Our ref: SU 946 073
Your ref: AL/117/12

25 February 2013

PLANNING APPLICATION: THE OLD BARN, ARUNDEL ROAD, FONTWELL, BN18 0SX

Layout 9 - Nearside Diverge Taper

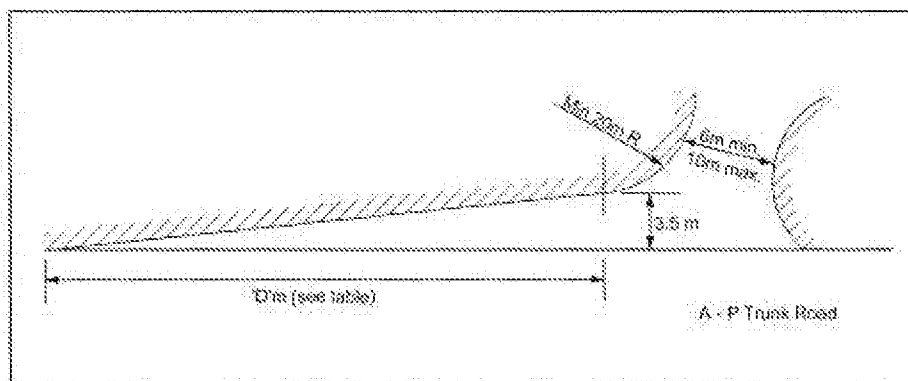
In principle we would be seeking an access/verge crossing to Layout 6 of TD 41/95 with a diverge taper in accordance with Layout 9. We would be pleased to discuss this further with the applicant and your council.

Layout 6 - Rural Access where long vehicles are predicted

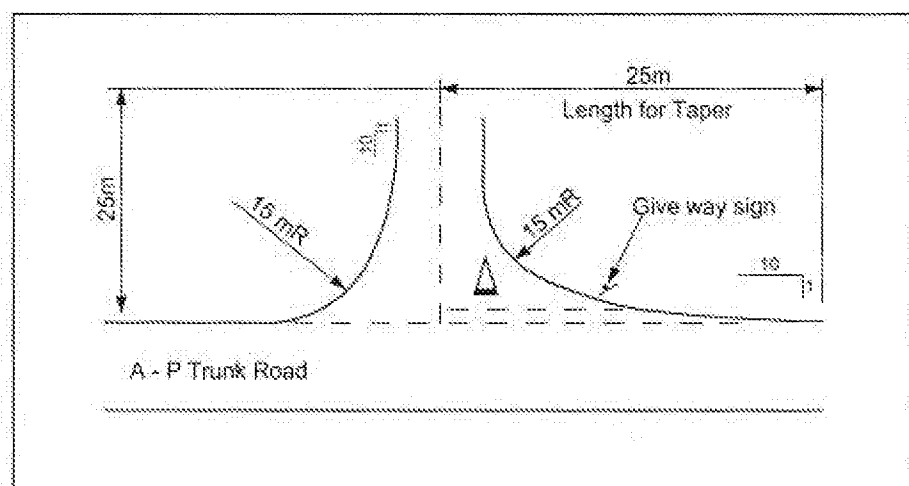
However we advise you that it would be desirable for the access (within the development site) to be modified to integrate with the widened verge crossing.
